From: Mark Warwick <Mark.Warwick@arun.gov.uk>
Sent: 19 March 2021 17:34
To: Simon Davis <Simon.Davis@arun.gov.uk>
Cc: Daniel Vick <Daniel.Vick@arun.gov.uk>
Subject: 261 Aldwick Road, Aldwick

Planning Application Ref: AW/279/18/RES

Location: 261 Aldwick Road Aldwick PO21 3QU

Purpose of visit: Ad-hoc inspection of approved Tree Protection Measures

Tree Retention and Protection Plan
261 Aldwick Road, Bognor Regis

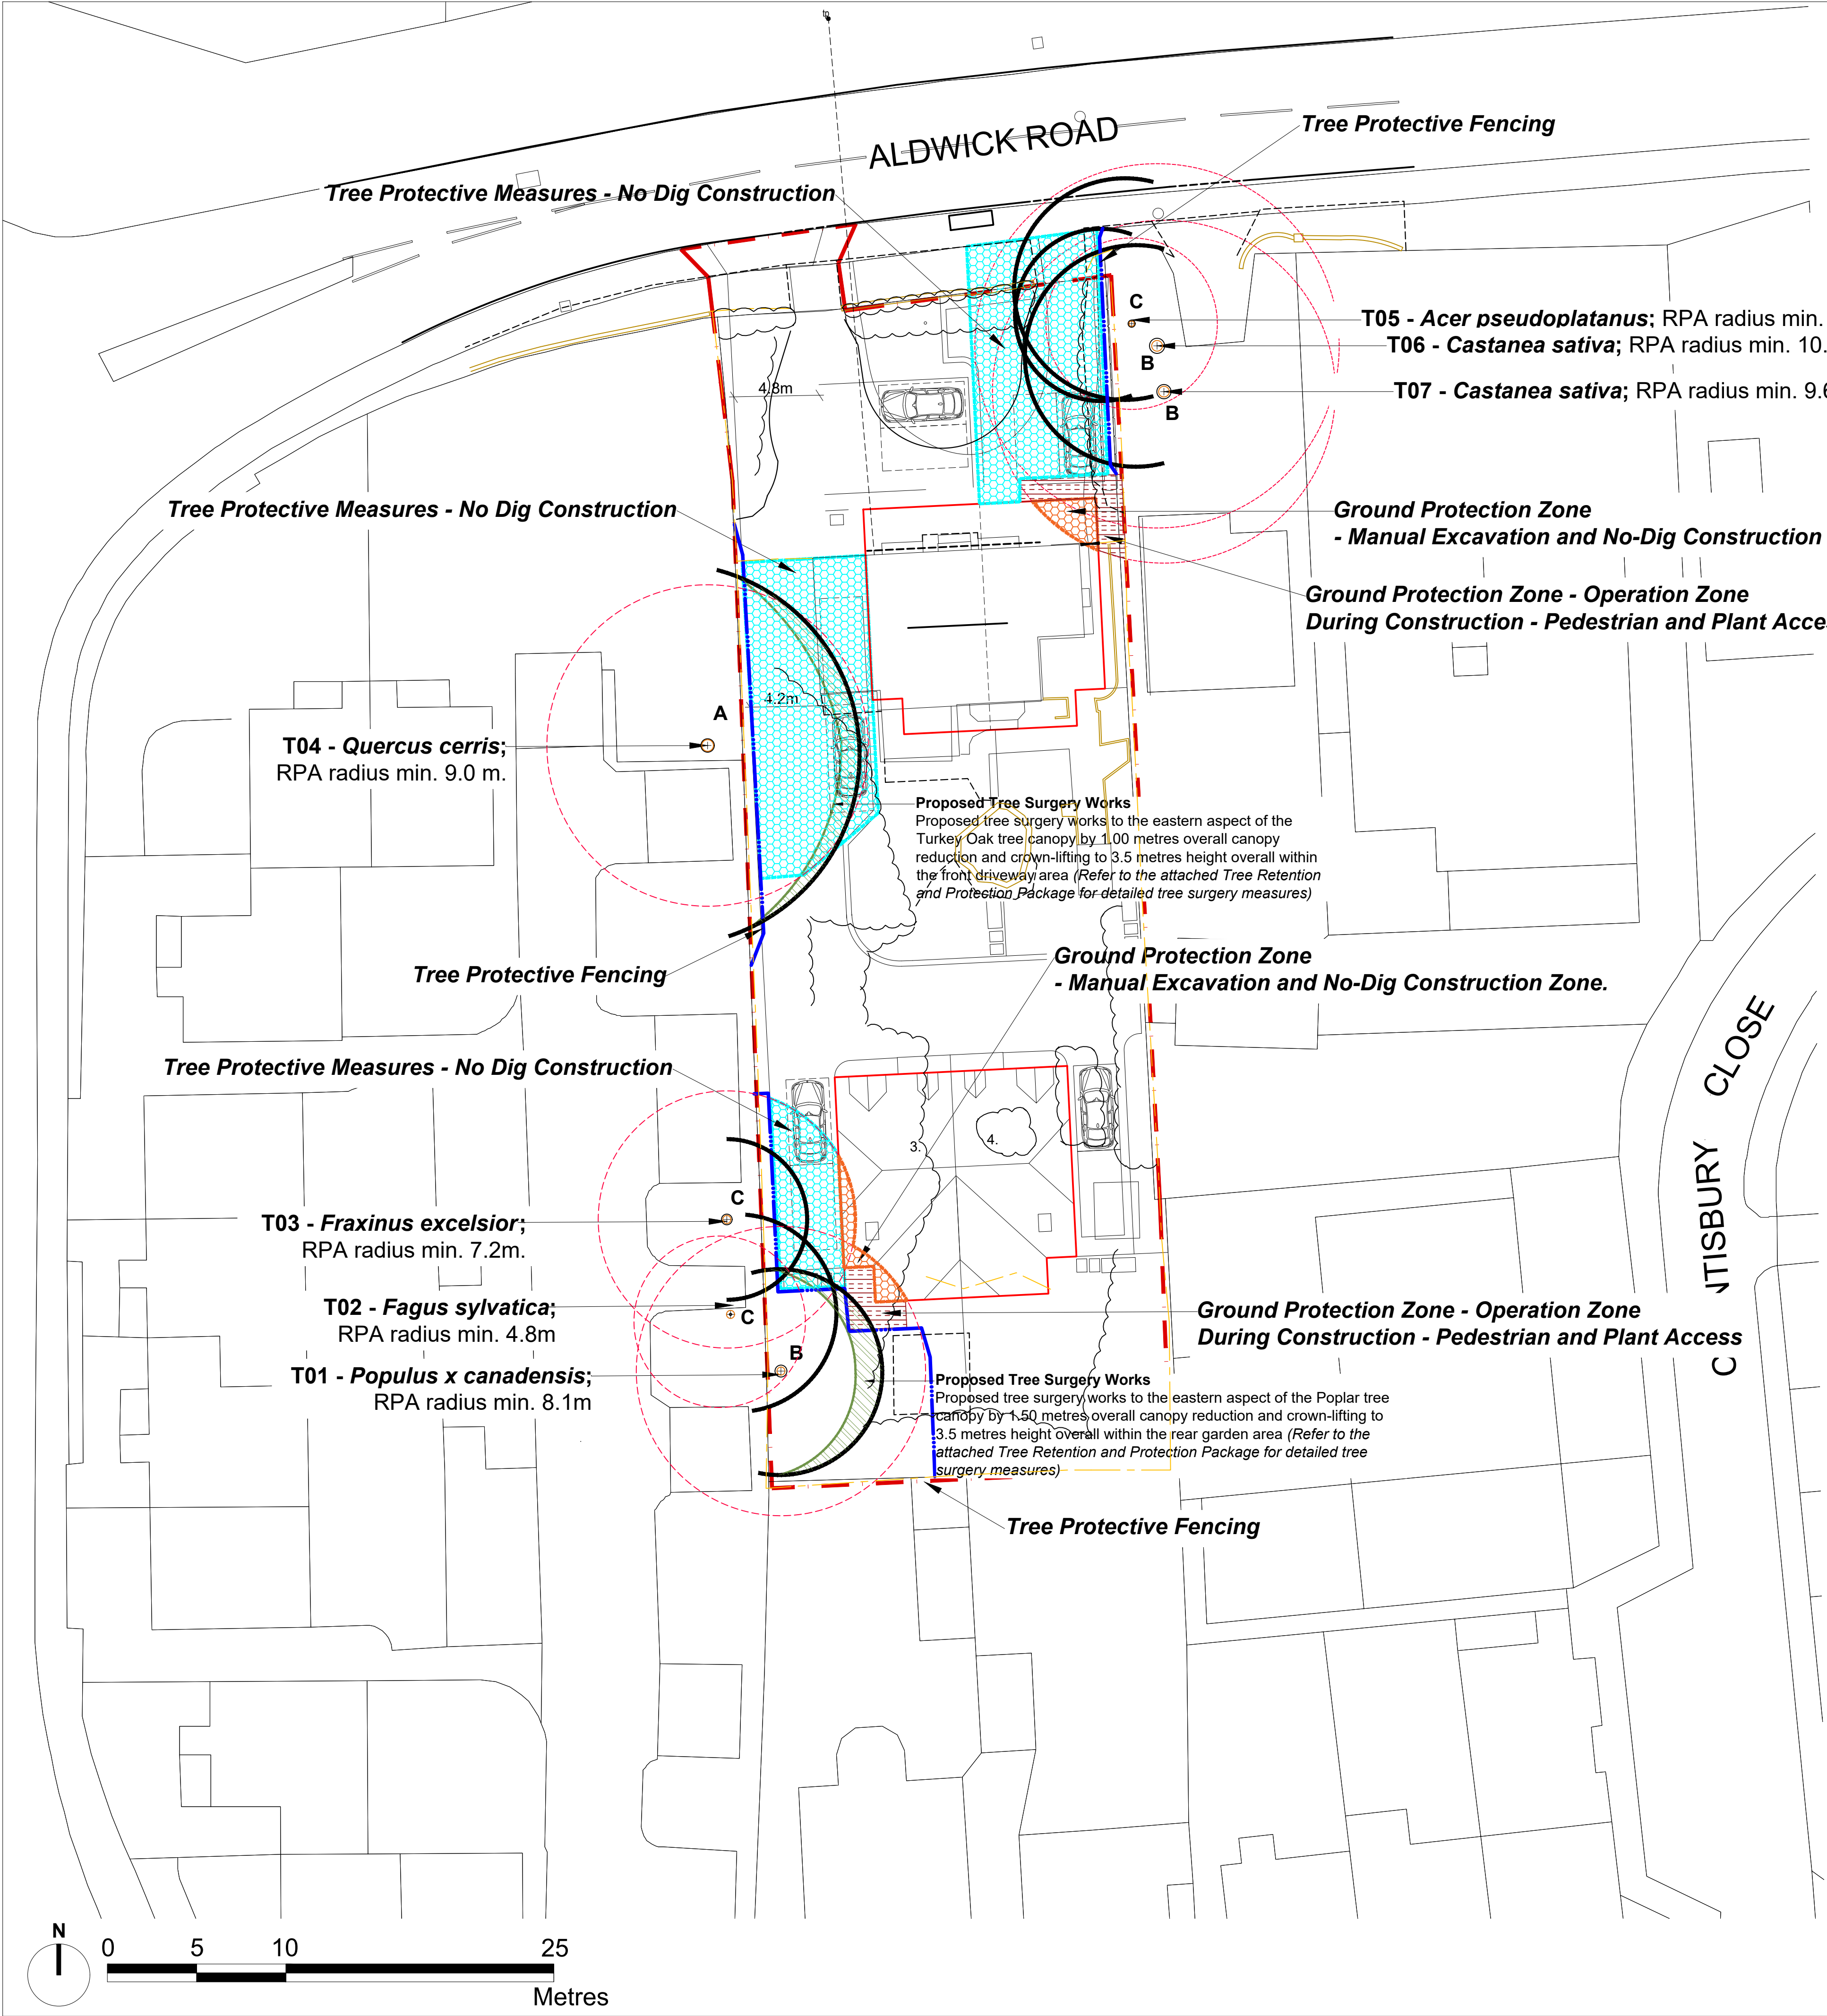
- While recently travelling en-route in the area I became aware of groundworks and construction activity occurring at the above site. An excavator was seen to be travelling across the Root Protection Area (RPA) of the high value, off-site oak tree (T04) in Malmayne Court. This tree is also the subject of a Tree Preservation Order. The site has been inactive for many months and since the last breach of condition; I attach my previous report which details the findings and outcomes from that event. As such, I was concerned to know if the approved ground protection measures remained effective. **Tree Retention and Protection Plan, LLD1425-ARB-DWG-002, Rev 02.** The following is a record of my observations and I draw conclusions and provide recommendations for remedial action.

- Groundwork across the site is advanced, with the footprint of all four plots dug out and above ground construction underway.
- Having been approached by one of the operatives (Dan, High Acre Construction), I was able to gain permission to enter the site and make an assessment of T04. The protective mats had been separated and scattered, with very little evidence of topsoil/mulch or woodchip in the RPA. It must be assumed that the bulk of that material has been incorporated and compacted into the subsoil. The geotextile membrane was destroyed. It was clear that a tracked vehicle had been active across large exposed areas of the RPA with consequential smearing and compaction of the soil.

- Materials are also being stored within the now unprotected RPA of T04.
- Despite large areas of RPA being identified for 'No-dig' construction, there was no preparatory ground protection in place. This 'No-dig' area has therefore been compromised once more and we need to ensure adequate ground amelioration and protection is undertaken promptly.

- Dan explained that this state was found when they were first attended site in the last week and that they had needed to construct a service run (open trench). This could doubtless have been achieved with the vast majority (if not all) of ground protection in place. We agreed a plan of action for the immediate short-term; that he would arrange for the boards to be dragged out to form a temporary (if only partially effective) level of protection so that they could conclude operations this week. I can confirm this had been undertaken within an hour of my attending site. I then spoke with Dan's manager, Keith Collier, mob [REDACTED] – who assured me that they would be finishing that phase of work today.

- It is likely that significant damage to the most valuable tree affected by the development has occurred once more, in the form of substantial ground compaction - as a direct result of the activity by groundwork contractors employed by the developer.
- Urgent action must be taken by the developer and their project arboriculturist to arrange for the careful removal of all materials stored within the RPA of T04, effective ground amelioration and installation of ground protection as per the approved plan – as mitigation and to prevent further damage.

- There is clearly a lack of oversight from the developer to ensure their sub-contractors understand why the Tree Protection Plan exists and what is required of them. This should be addressed urgently with a 'toolbox talk' from the

project arboriculturist, as recommended in the approved **Arboricultural Impact Assessment and Method Statement, LLD1425.ARB-REP-001, Rev 02** (para. 5.5).

- This incident should be investigated to determine how this event occurred and referred to our enforcement team to consider any further action. Given the gravity of these omissions, the probable extent of damage sustained and risk of ongoing damage occurring; my personal recommendation is that you place a **Temporary Stop Notice** across the site until such time as we are confident that appropriate investigation, ground amelioration, installation of approved protection measures has occurred under the direction and supervision of their project arboriculturist.
